Council Reference: DA18/0685 LN40120  
Your Reference: SSD 9575

**State Significant Development SSD 9575 (Council Reference DA18/0685) - Concept Application, Stage 1 works and SEPP to Amend Tweed LEP 2014 for new Tweed Valley Hospital (NSW Planning & Environment App No. SSD 9575) at Lot 11 DP 1246853; No. 771 Cudgen Road CUDGEN**

**Annexure 1**  
**MATTERS FOR CONSIDERATION BY THE DETERMINING AUTHORITY**

Project Name  
TWEED VALLEY HOSPITAL  
DEVELOPMENT, KINGSCLIFF,  
NSW  
Drawing Title  
CONCEPT INTERSECTION WORKS  
PLAN SHEET 1 OF 2

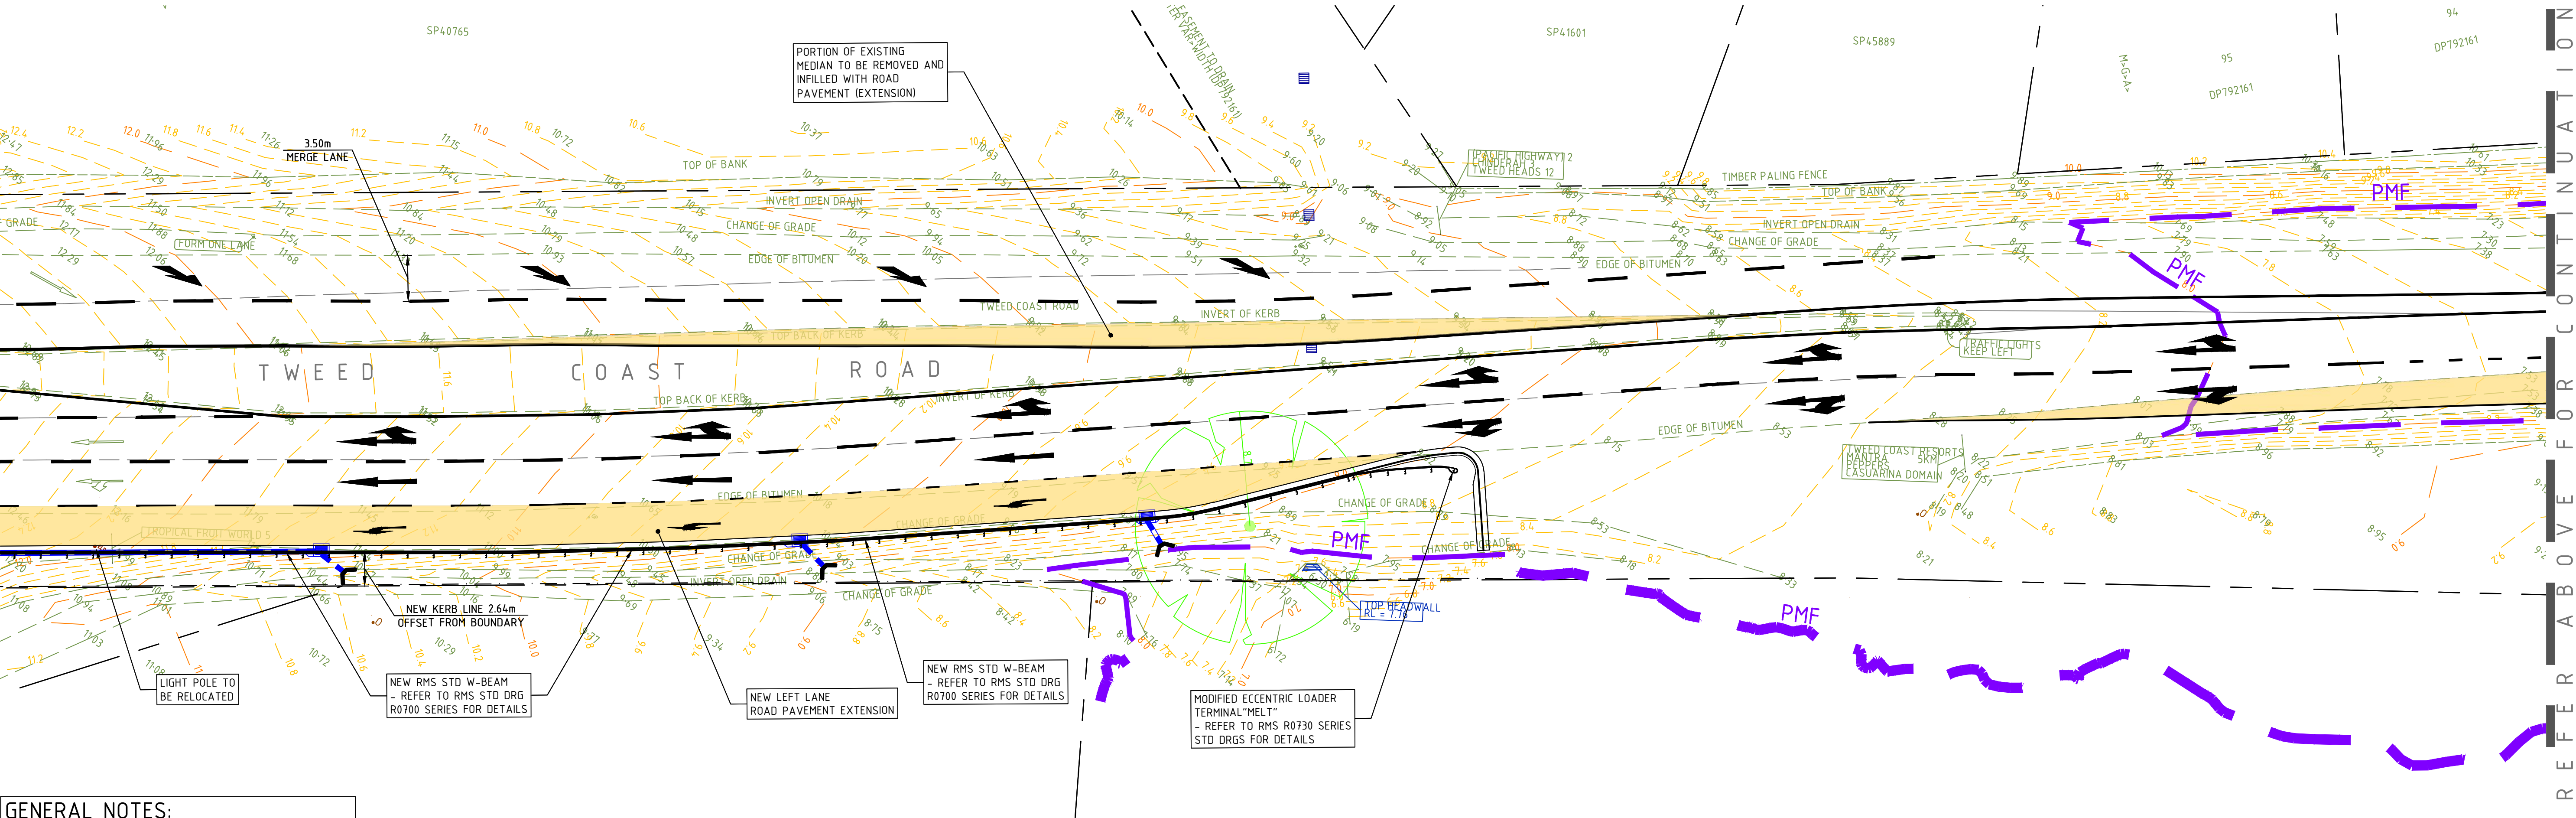
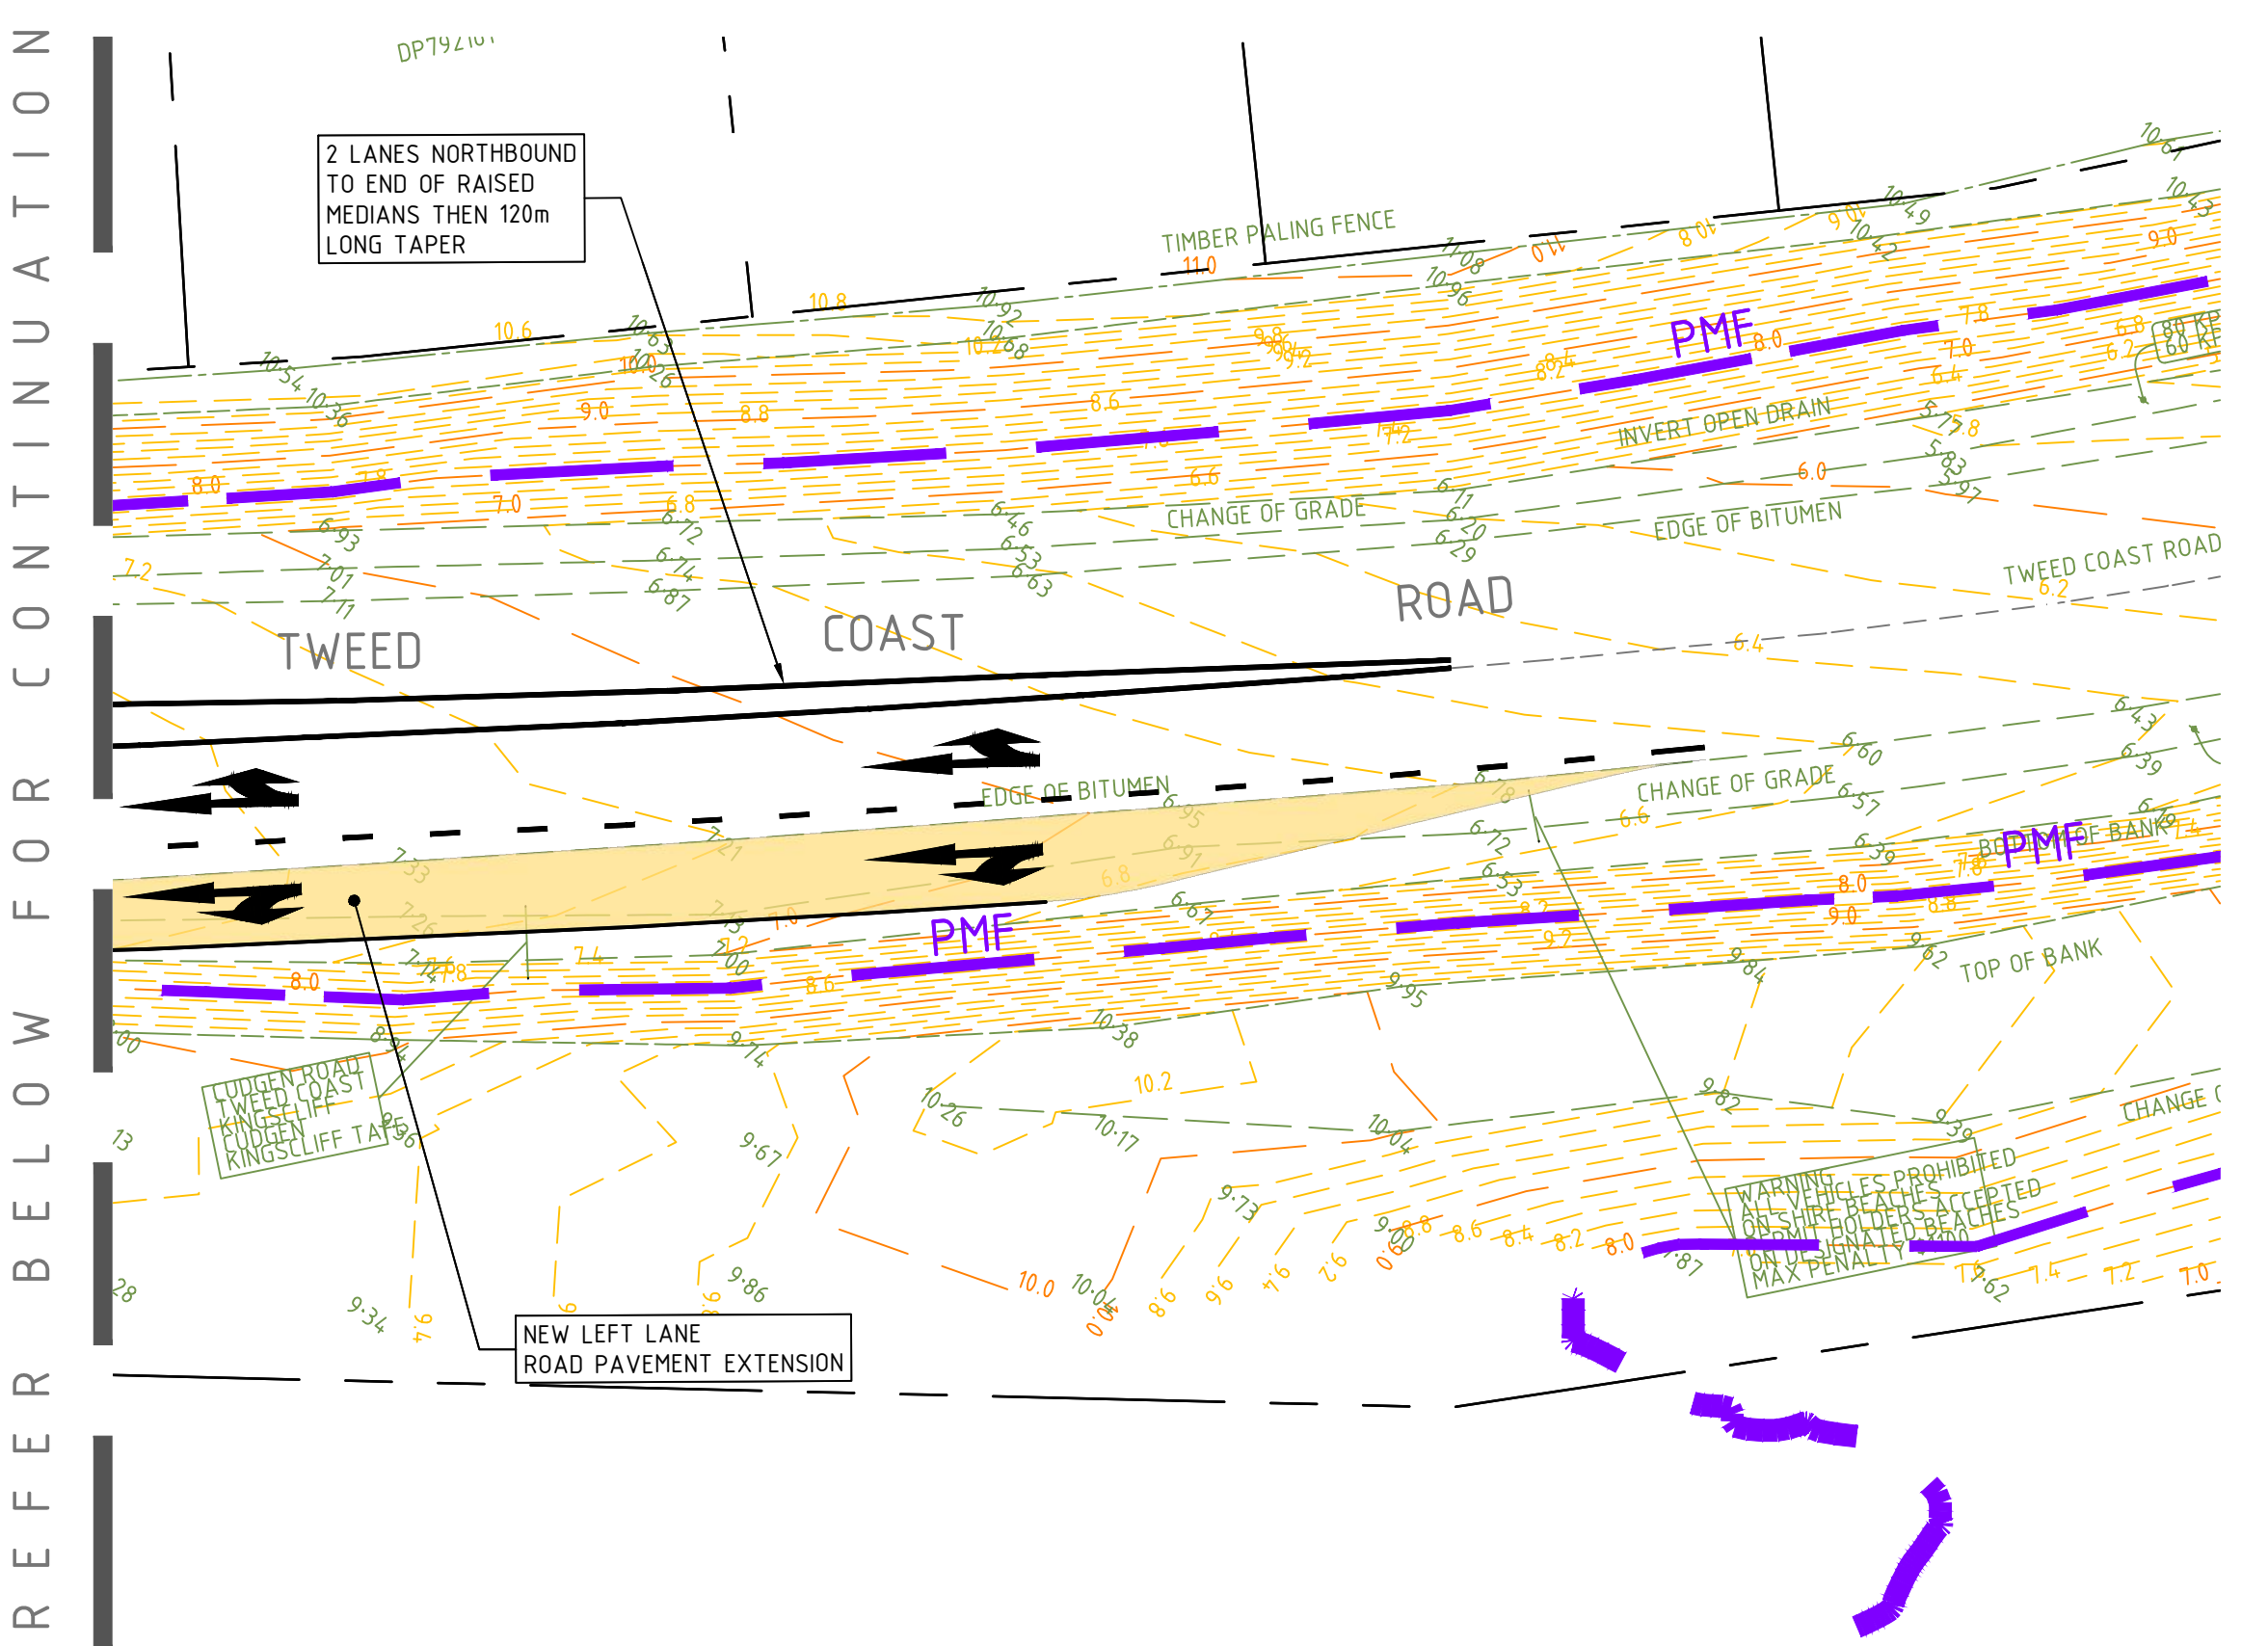
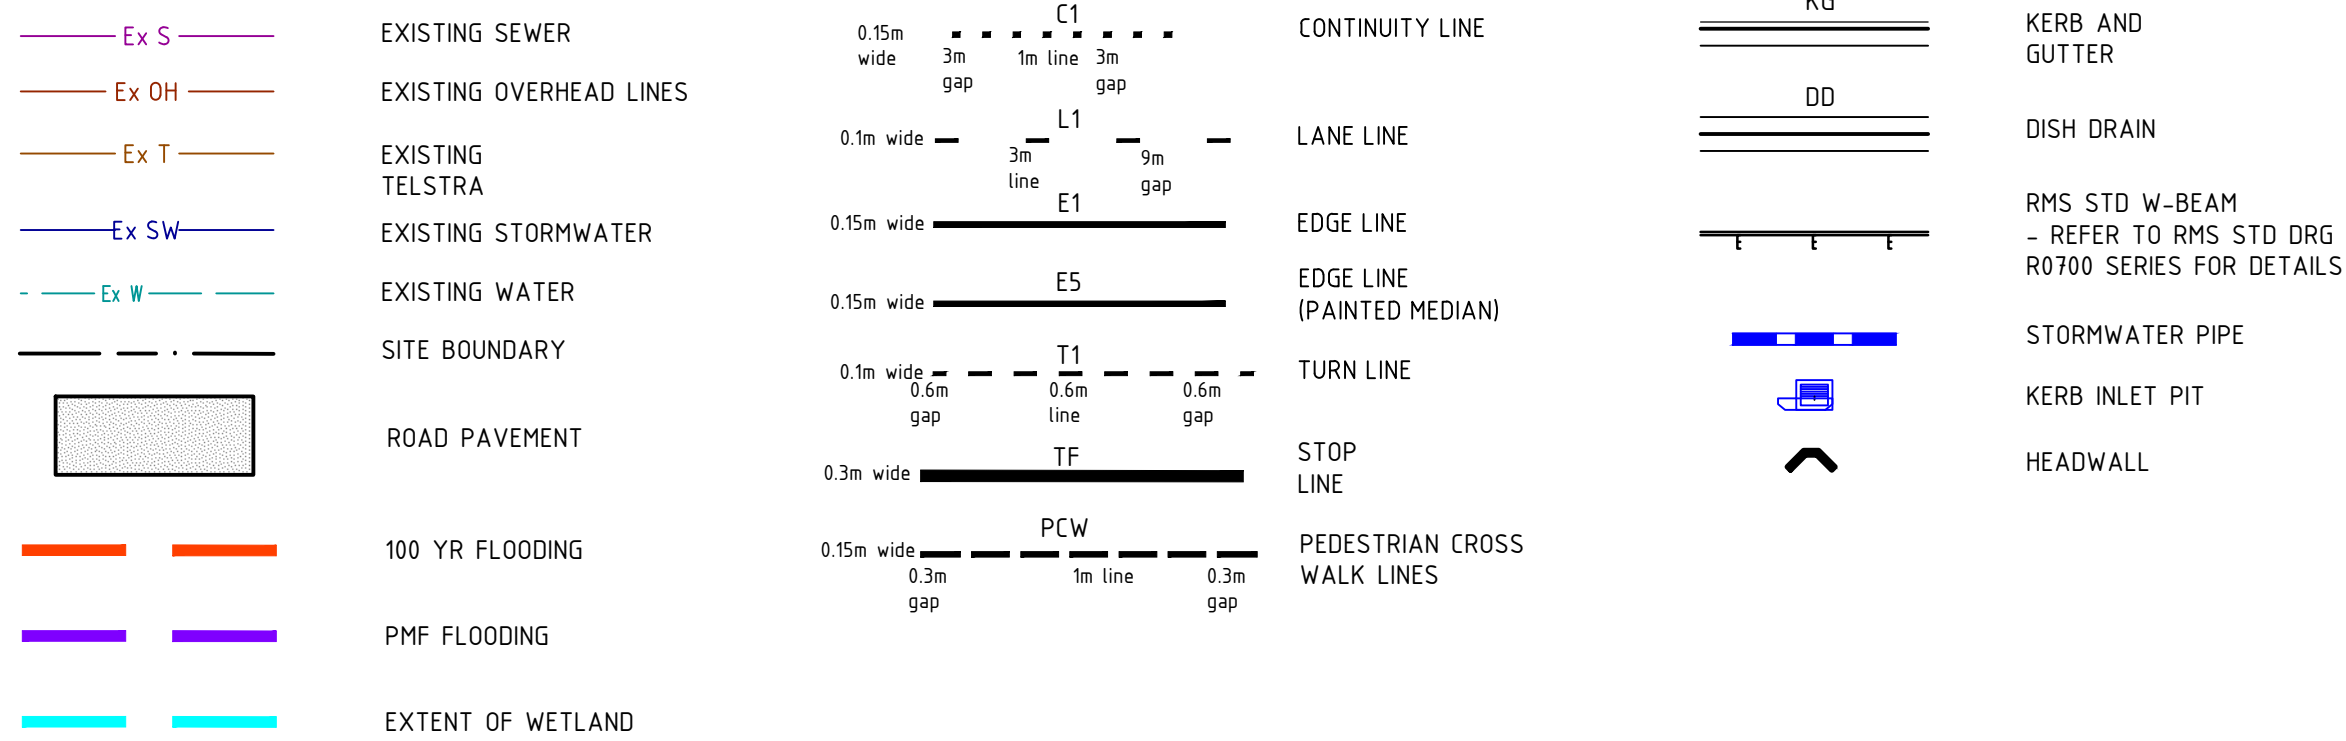
#### **Cudgen Road/Tweed Coast Road Intersection**

The report identifies that by 2023 without the impacts of the Hospital traffic that the intersection would operate outside acceptable performance limits. A series of upgrades referred to as Upgrade 1 were modelled at the intersection. The upgrades improved the intersection's operation at peak hour to a practical capacity Degree of Saturation. This modelling did not include the traffic impacts from the Hospital.

Further upgrades are identified as being required at the intersection at the year of opening labelled as Upgrade 2 shown in section 5.3.3.

Therefore, before opening of the Hospital the intersection needs to be upgraded as follows

- Addition of a 100m southbound left-turn lane on Tweed Coast Road;
- Phase sequence change to allow the southbound left-turn to overlap with the westbound right-turn (i.e. possible with the provision of dedicated southbound left-turn lane);

- Lane discipline change for the two approach lanes on the south-eastern approach:
  - Change of the left through lane to a through and right lane;
  - Change of the right through and right lane to a right only lane;

- Extension of the south-eastern short departure lane from approximately 75m to approximately 150m;
- and
- Extension of the northbound departure lane from approximately 85m to approximately 100m; and

- Conversion of the north-western leg departure to a single lane (no physical changes. i.e. through provision of chevron line marking). With the lane discipline changes on the south-eastern approach, there is only one lane travelling through to the north-western departure lane.

- Further upgrades are required to cater for the additional Project traffic in Year 2023, including:
- Extension of the northbound departure lane to approximately 200m; and
- Extension of the southbound departure lane to approximately 150m.

Any works associated with the Tweed Coast Road / Cudgen Road intersection should be commensurate with Council's ultimate plans for Tweed Coast Road

#### ***I. Before opening of the Hospital the intersection of Tweed Coast Road and Cudgen Road needs to be upgraded as follows***

- ***Addition of a 100m southbound left-turn lane on Tweed Coast Road;***
- ***Phase sequence change to allow the southbound left-turn to overlap with the westbound right-turn (i.e. possible with the provision of dedicated southbound left-turn lane);***

- ***Lane discipline change for the two approach lanes on the south-eastern approach:***
  - ***Change of the left through lane to a through and right lane;***

- ***Change of the right through and right lane to a right only lane;***
- ***Extension of the south-eastern short departure lane from approximately 75m to approximately 150m;***

- ***Extension of the northbound departure lane from approximately 85m to approximately 200m; and***
- ***Conversion of the north-western leg departure to a single lane (no physical changes. i.e. through provision of chevron line marking). With the lane discipline changes on the south-eastern approach, there is only one lane travelling through to the north-western departure lane.***

- ***Extension of the southbound departure lane to approximately 150m***

#### ***J. Any works associated with the Tweed Coast Road / Cudgen Road intersection should be commensurate with Council's ultimate plans for Tweed Coast Road***
